Consultation Response from: KC Environmental Health (Pollution & Noise Control)
2025/92459 - 10A Regent Street, Heckmondwike, WF16 0HD
Change of use of taxi booking office and car park to hand car wash
Responding Date:
12 December 2025

Responding Officer:
Mohammed Nasim

Responding Ref:
WK202536794

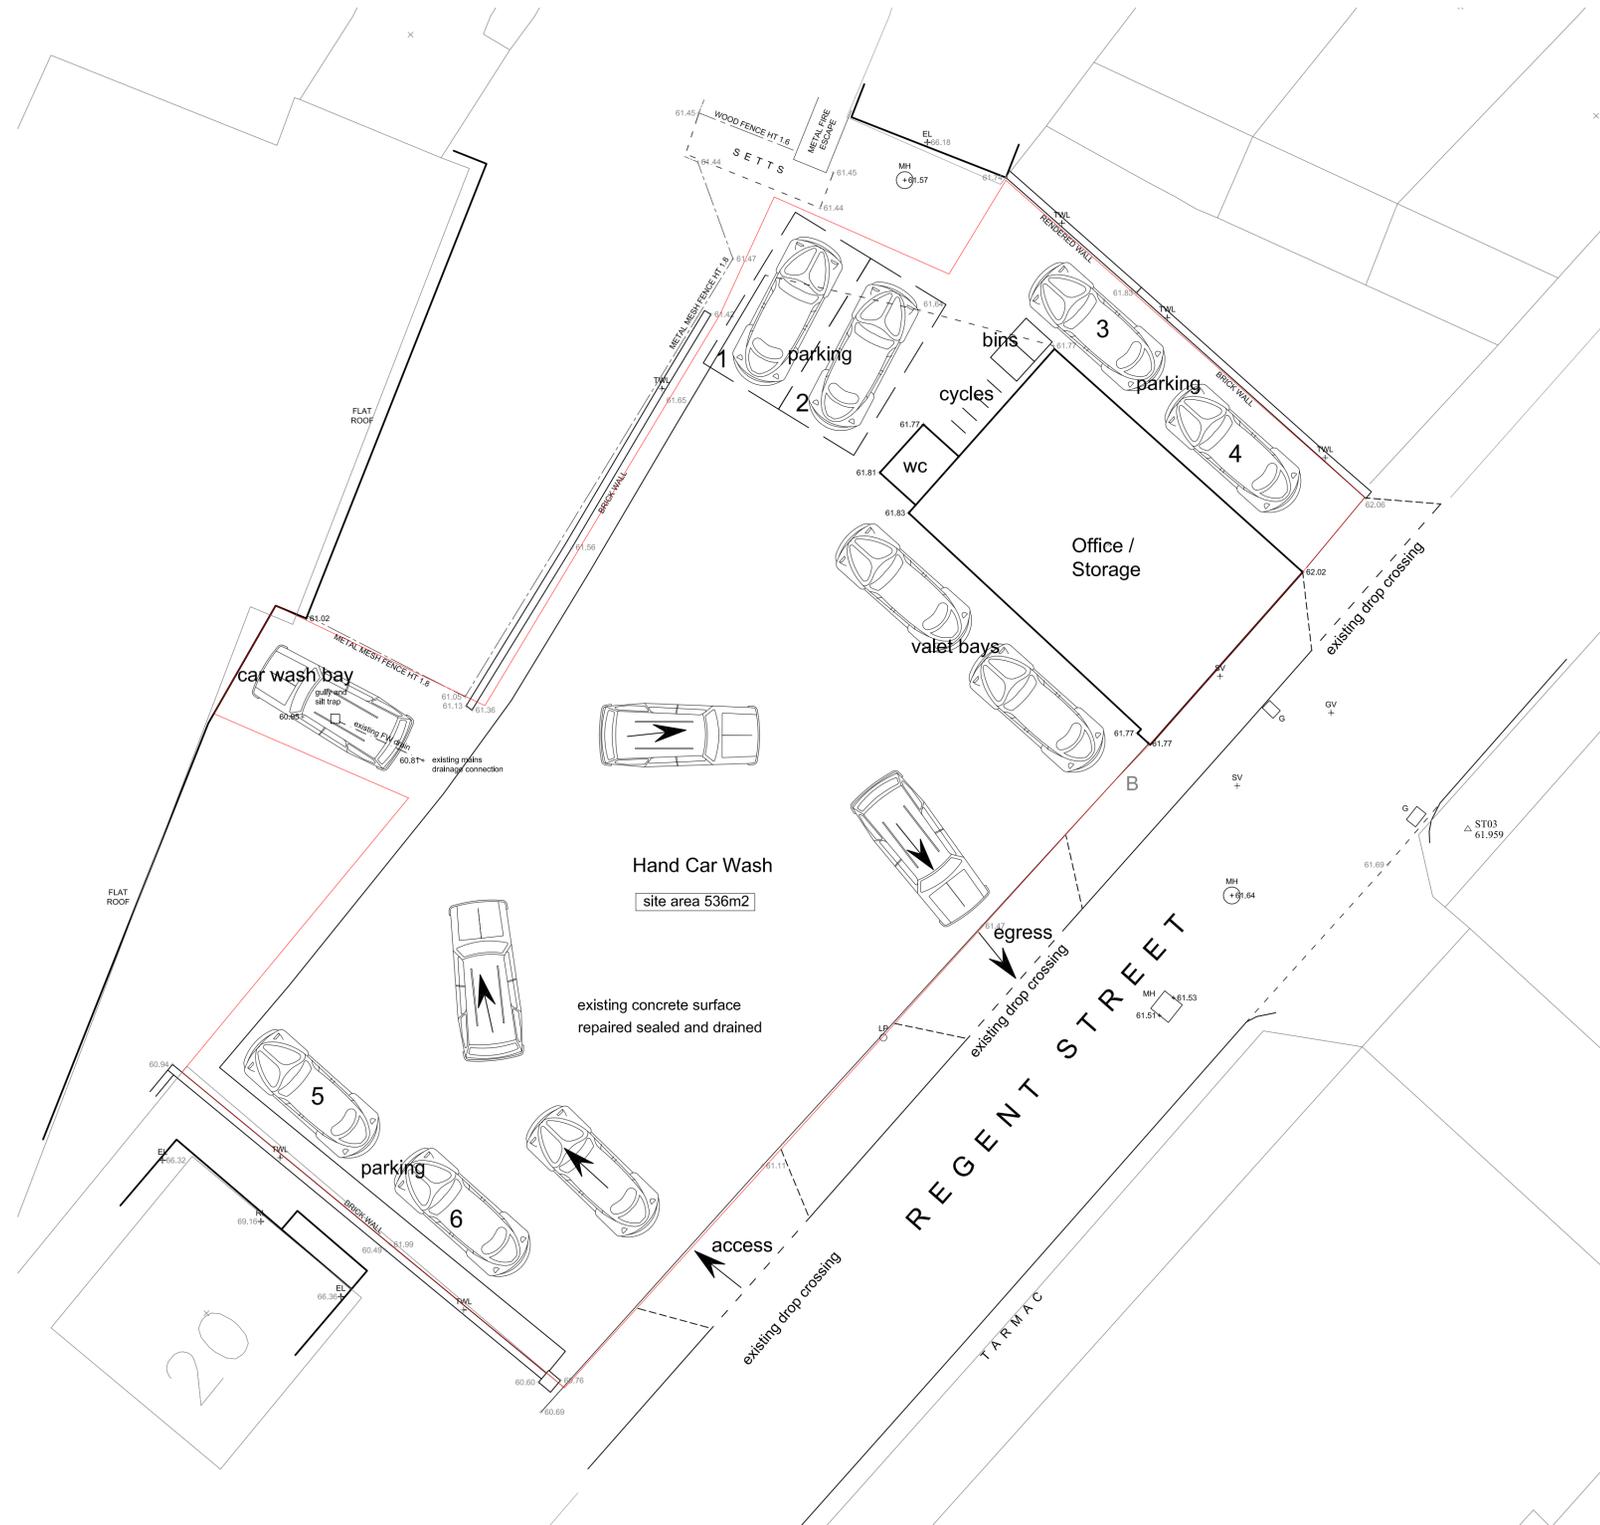
Due to some uncertainties within the report, we spoke with the author who clarified the distance and barrier corrections along with the proposal that all of the pressure washer equipment will be stored within the basement of the office area, as shown in the proposed site plan in Appendix A, with the hoses being the only exposed equipment associated with the operation of the plant. Only the vacuum cleaner in the valet area would be 'on site'. The sound insulation requirement was also discussed with the author admitting to an incorrect figure being quoted.

A condition is recommended to ensure the jet washes are housed in the basement in the interests of protecting amenity.

NC14 Implement Agreed Noise Mitigation Measures – Condition

The development shall not be brought into use until all of the mitigation measures specified in the approved Noise Impact Assessment by Paul Horsley Acoustics dated 13 November 2025 Ref J3373 Rev1 have been carried out in full and such measures shall be thereafter retained.
